COTTAM SOLAR - Deadline 1 – 17 October 2023

Part 2 - APPENDIX 2 – Hedgerows/Views - Photographs/Photography raised at Open Floor Hearing Oral submission – Tuesday 5th September 2023.

ENVIRONMENTAL STATEMENT APPENDIX 8.1.5: PHOTOGRAPHY AND PHOTOMONTAGE METHODOLOGY PART 1 OF 5 January 2023

Viewpoint 1 (Winter)

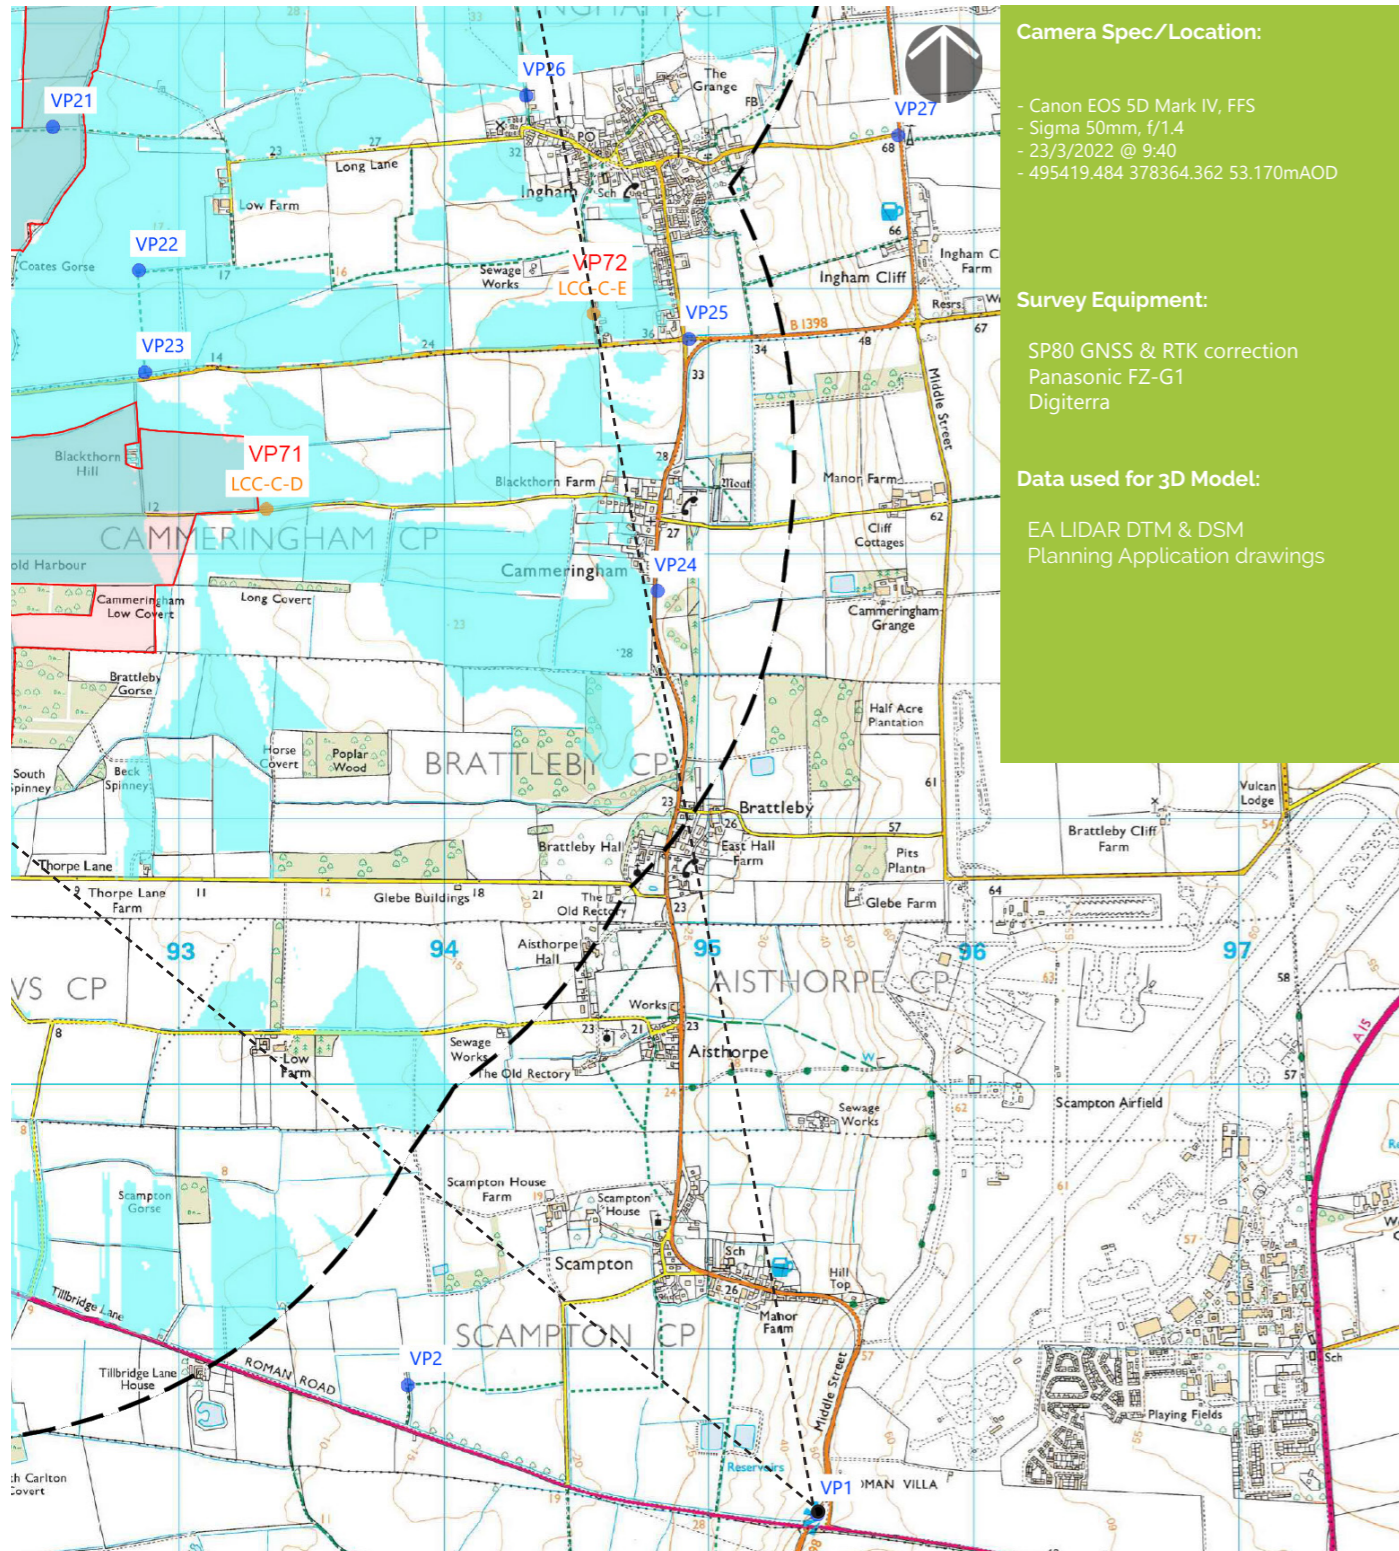
*I must question the actual ‘spot’ the photographer’s images have been taken from the Scampton Viewing Point – there are openings in the hedge at the viewing point location where there is a clear view of the distant extensive landscape beyond – see writer’s images on the following pages taken October 2023 which show the two Power Stations some 15 miles distant with plumes of steam erupting from each one. Again there is a clear and extensive view of the landscape beyond and travelling along the A1500 from the junction of the A1500 / B1398 towards Sturton by Stow there are no hedges to obscure the view all along the roadside to the right hand side with clear views across to Thorpe le Fallows, and the trees in the distance on Ingham Road, on the outskirts of Stow.*

Is this an attempt to 'discredit' the open views that we see daily on this landscape? There are areas along this length of hedgerow with a clear view as my own image(s) demonstrates in this submission, which were taken just yards away from where the photographer's image was taken for the Environmental Statement.

Viewpoint 6 Single Frame 50mm image (Winter)

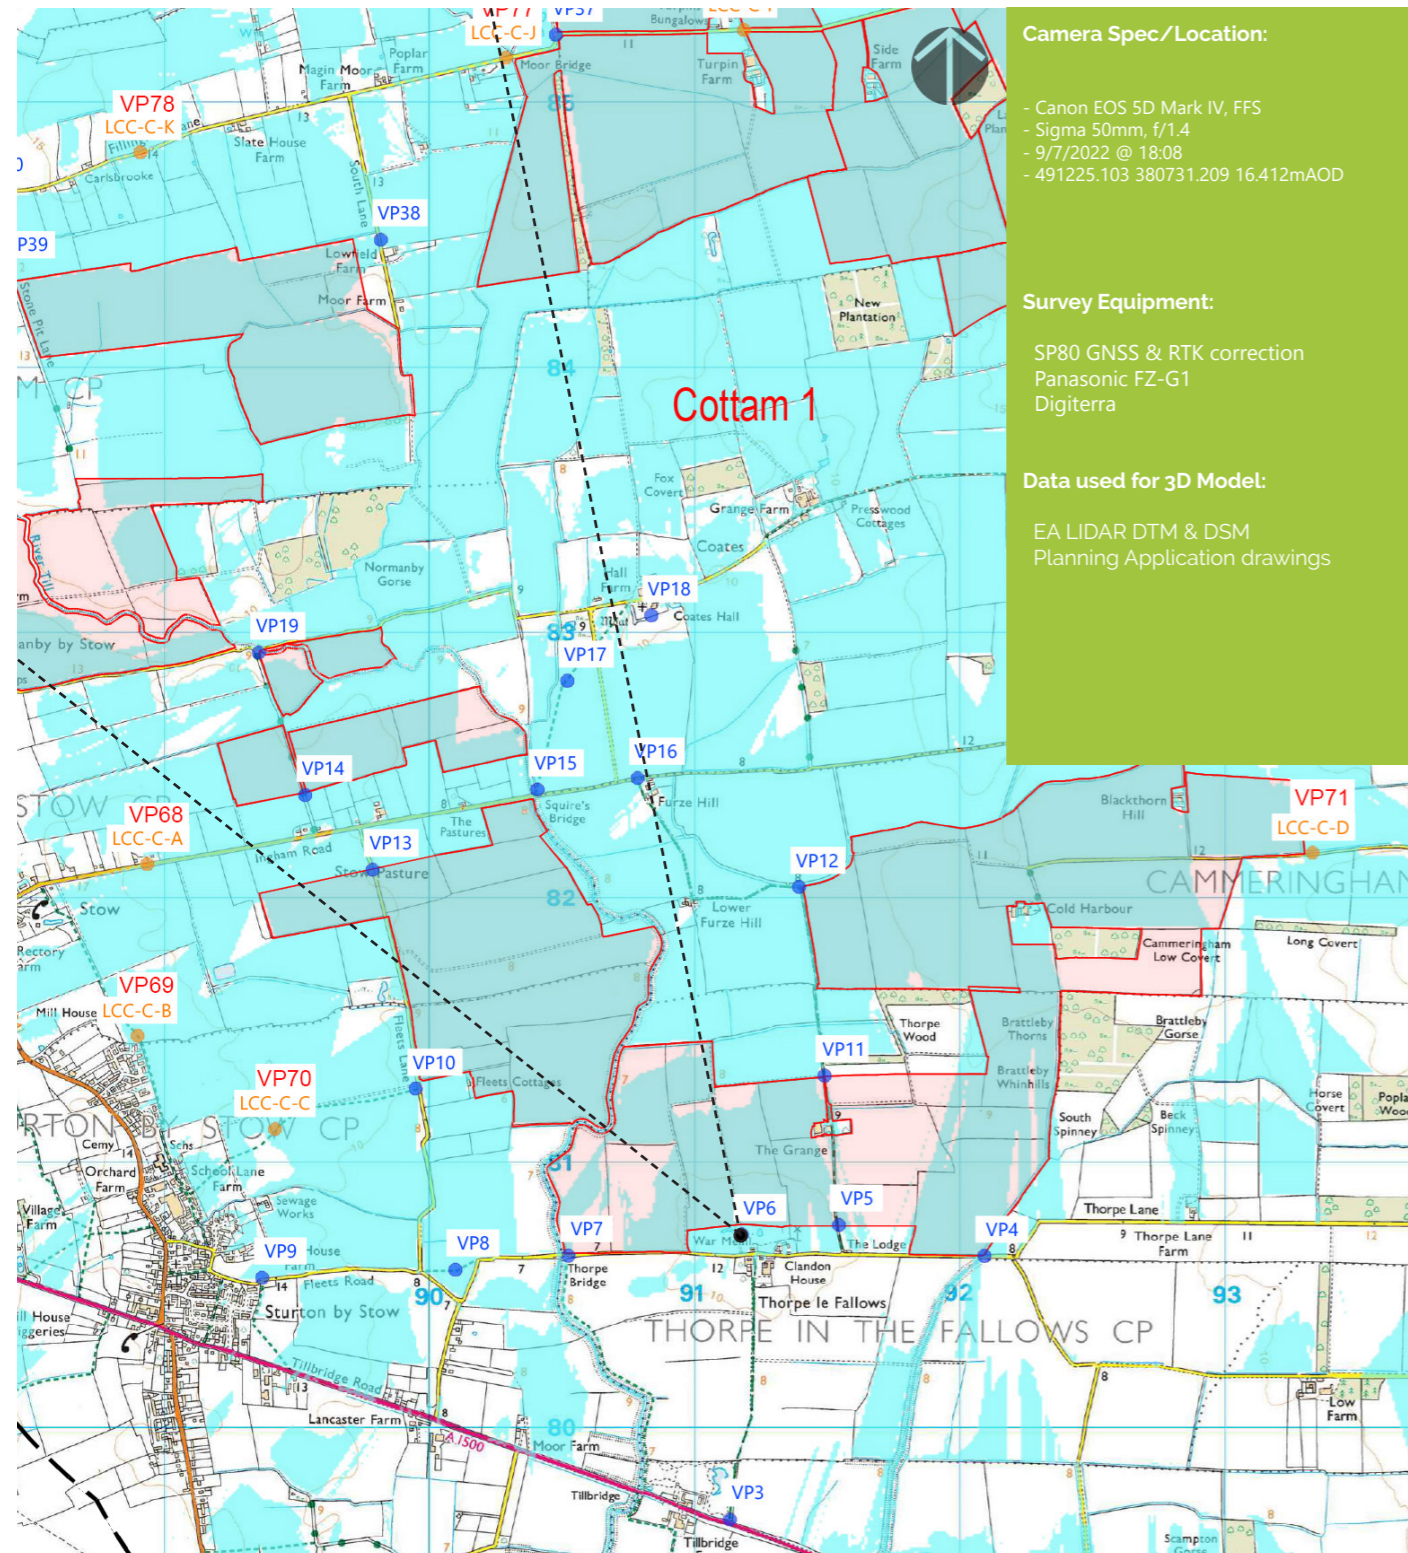
**Viewpoint 6** - The image opposite is part of the Environmental Statement of packages of Photographs taken *in one of the fields at Viewpoint 6 at the medieval hamlet of Thorpe le Fallows on Thorpe Lane*. It illustrates a 'before and after' the installation of the 4.5m tracking solar panels. It is such a small image I have copied from the original that it is difficult to see the scale of the solar panels that are in this photomontage but it is clear to see the wide open landscape 'before' view is a wonderful vista and 'after' view is horrendous. A larger version can be seen at the end of this document but the reader must view it in the Environmental Statement Photography/Photomontage document it appears. There is no indication in the writers submission as to scale of the solar panels in the landscape, nor any clear images of associated hardware, including security fencing and cameras the cameras being considerably taller than the panels. It is understood the solar panels will be 4.5m tracking.

Viewpoint 9 Single Frame 50mm image (Winter)

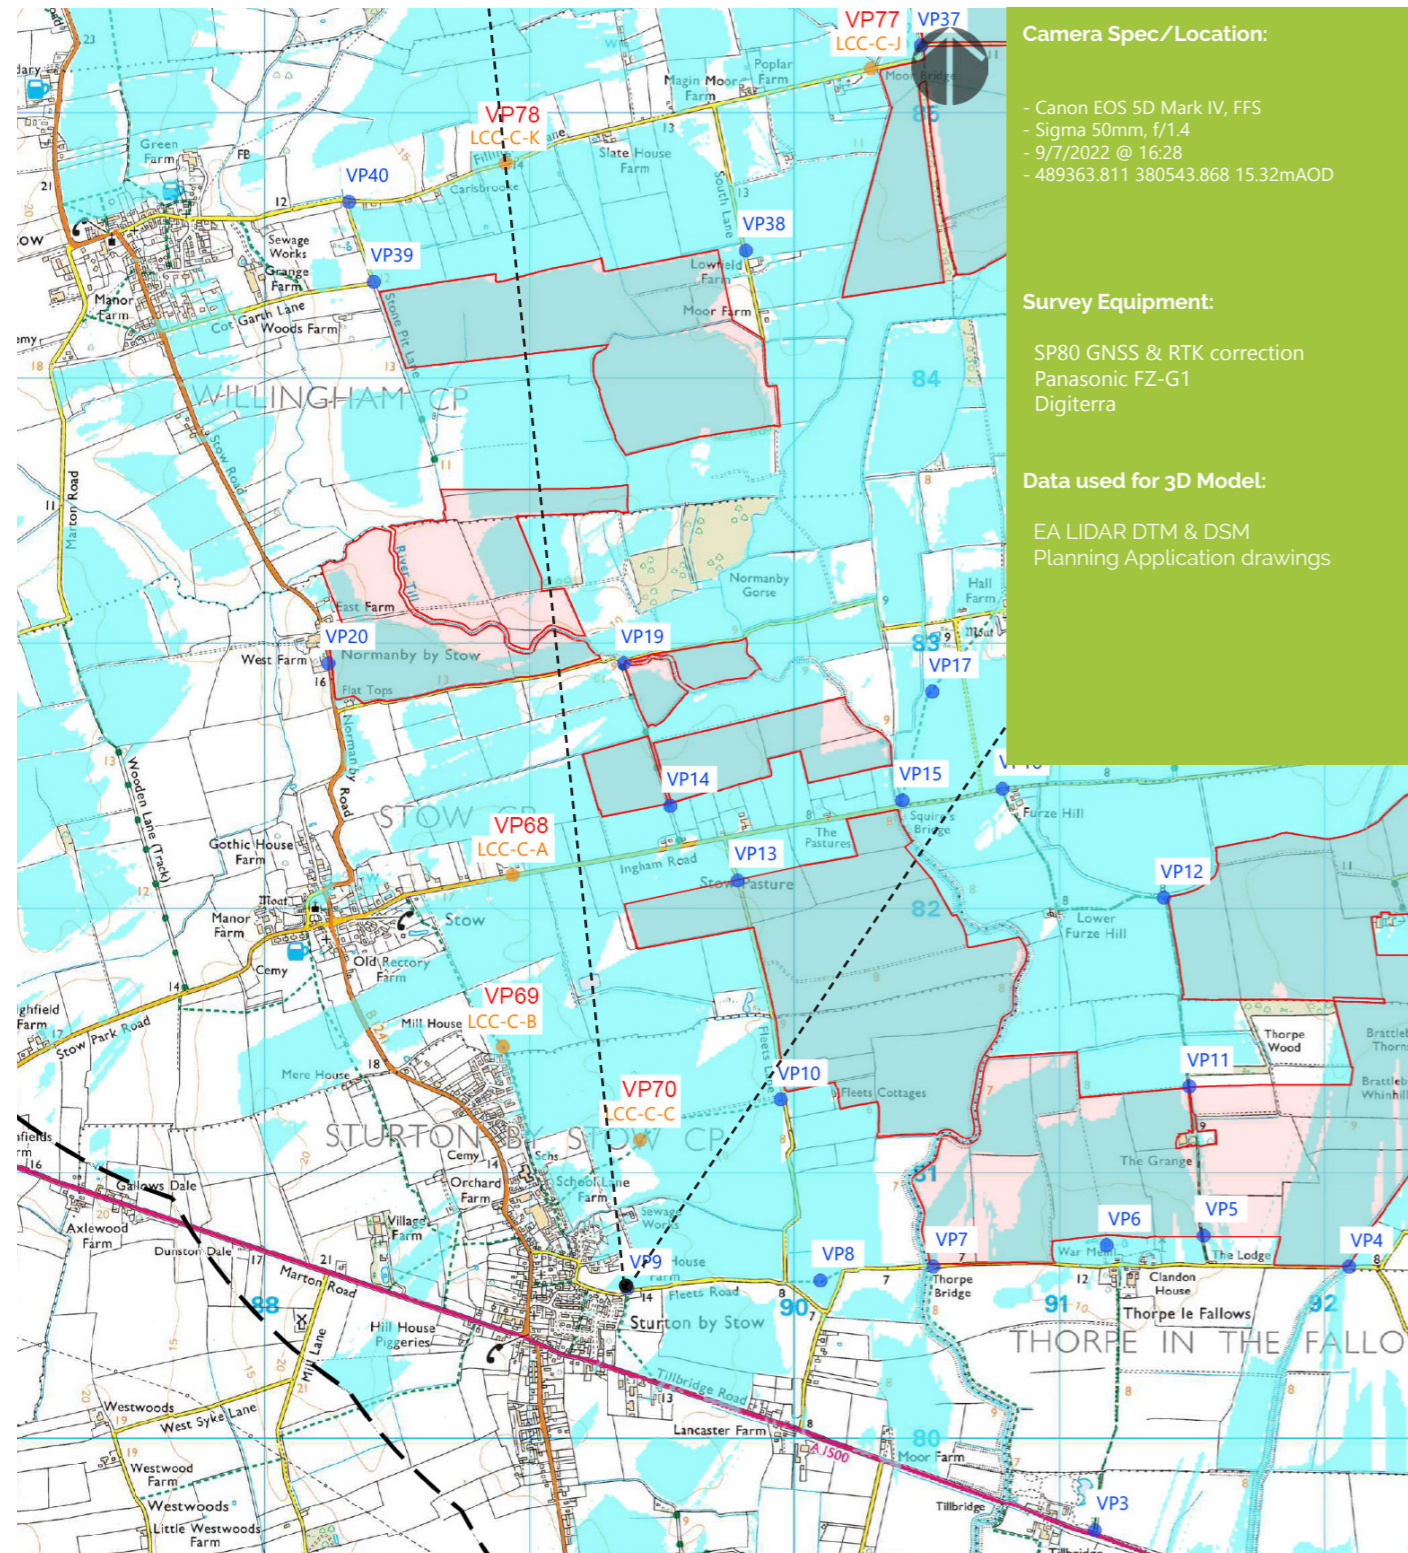
It is impossible to know if the summer photographers image above contained in Methodology Part 1 of 5 page 1 was taken at the same location as the Winter image (Viewpoint 9) as none of the three trees are visible in that summer image, compared to the writer's image below also taken on a sunny day on 25 September 2023 at the exact location as the Winter image above.

The writer knows this area incredibly well and I cannot see the logic of why the images at page 1 above are in the Environmental Statement Appendix. It makes no sense to take a photograph, through the native hedgerow, of the white plastic bio-mass crop storage structure, which was in the next field and temporarily blocking the view of the extensive landscape beyond and which the PRow (public footpath) through farmland (Viewpoint 10) can be seen ? **WHY ?** This 'storage facility' is no longer there as can be seen from the writer's own Summer image taken 25th September 2023 below. Please refer to the original images contained in the Environmental Statement Appendix above for enlargements of the 'Lanpro' photographer's original images.

A little further along Fleets Road from the **Winter Viewpoint 9** single frame photographer's image above and the writer's Summer image of Viewpoint 9 above, the writer took two further photographs shown below on 25th September, 2023, from public land. The images show the extent of the open landscape beyond this field to the Lincoln Cliff Jurassic Escarpment some 7 miles distant but also Cottam 1 solar would be highly visible beyond Fleets Lane from this view. **WHY** would the photographer not take images of the landscape and view beyond at this point instead of straight at the hedge as shown in the Environmental Statement Appendix images at Viewpoint 9 ?

Viewpoint 10 Single Frame 50mm image (Summer)

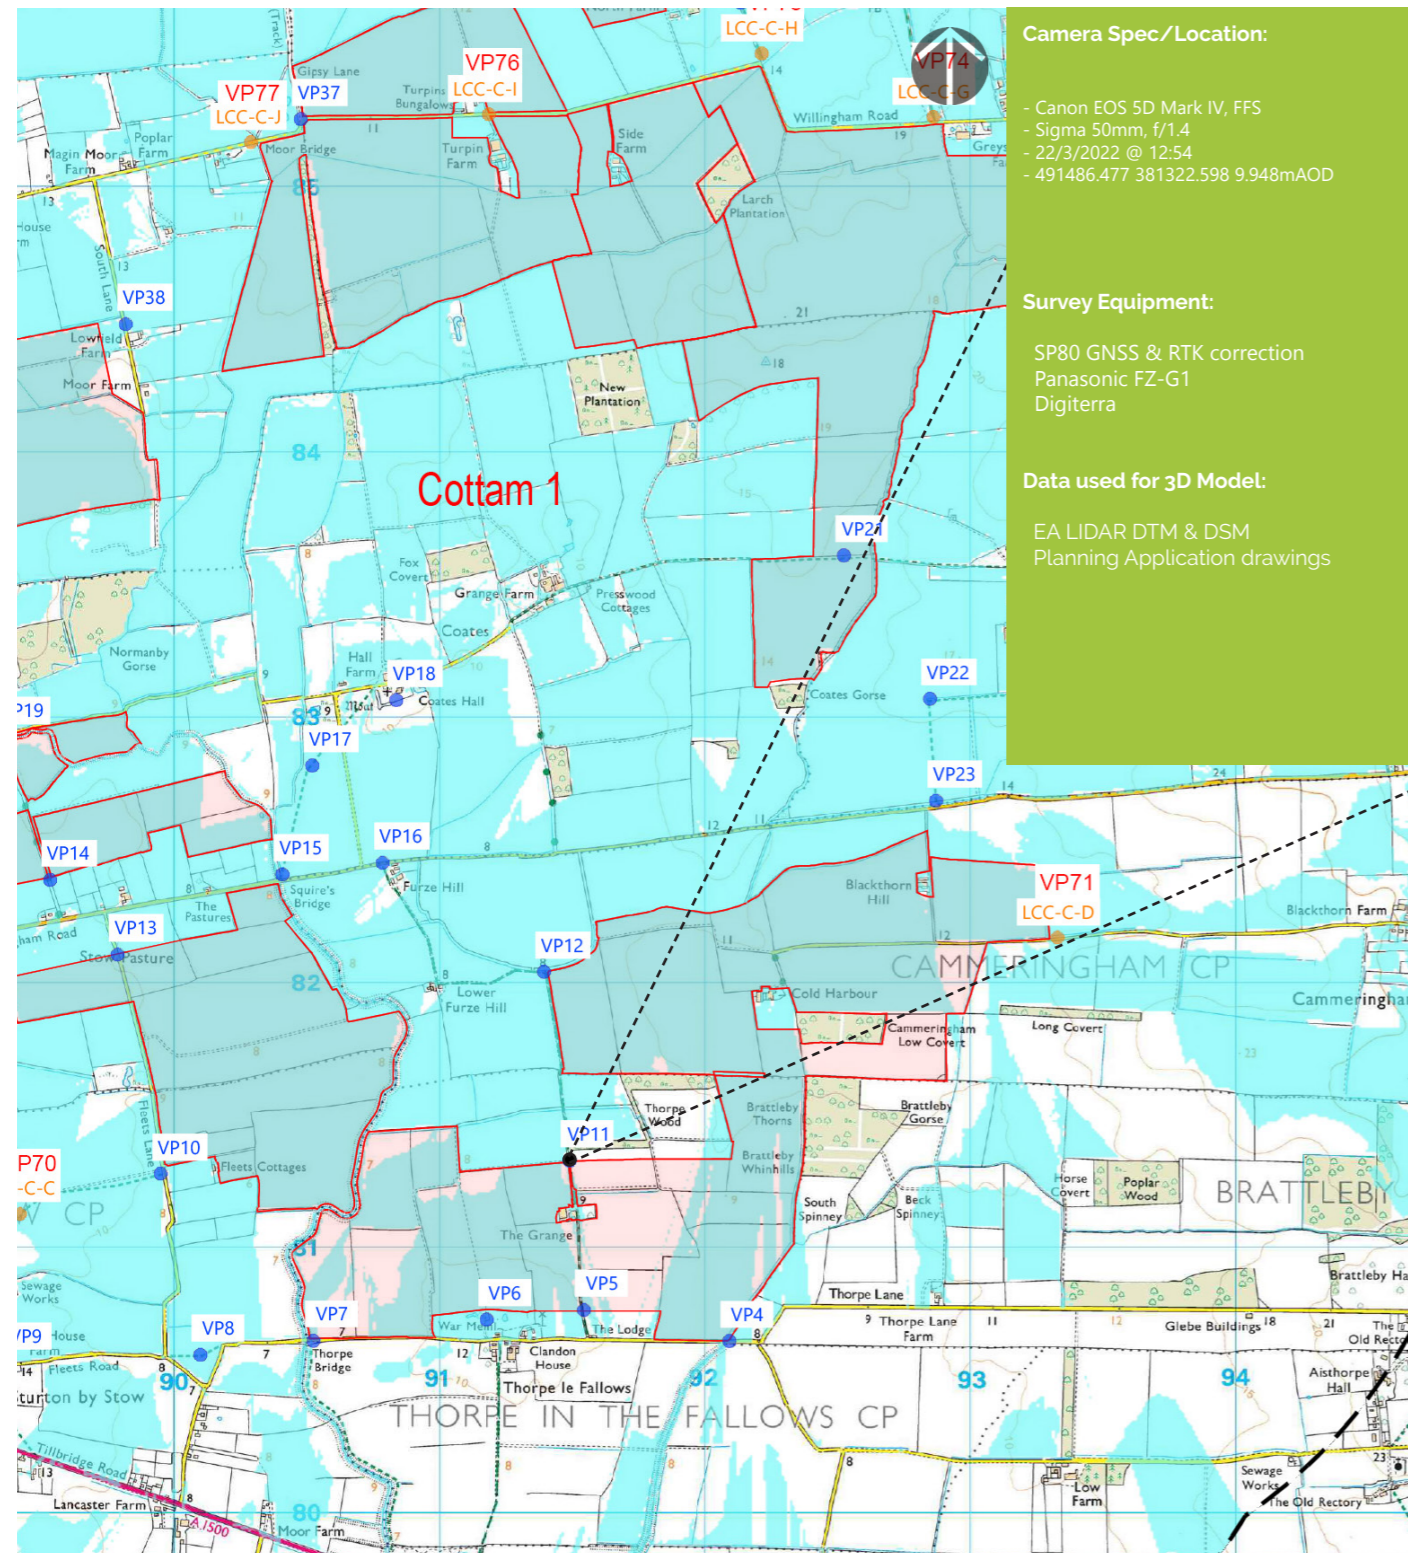
The cottages are a focal point on the open landscape. In Viewpoint 10 below the photographer has taken an image of the field that adjoins the lane to the two cottages which are not to house solar panels but the fields beyond behind it and the fields along the length of Fleets Lane leading to Ingham Road Viewpoint 13 at Stow Pasture will contain solar panels.

**WHY** has the photographer excluded the above cottages from the image below left from the Environmental Statement at Viewpoint 10 ? They will be so very greatly affected by this scheme.
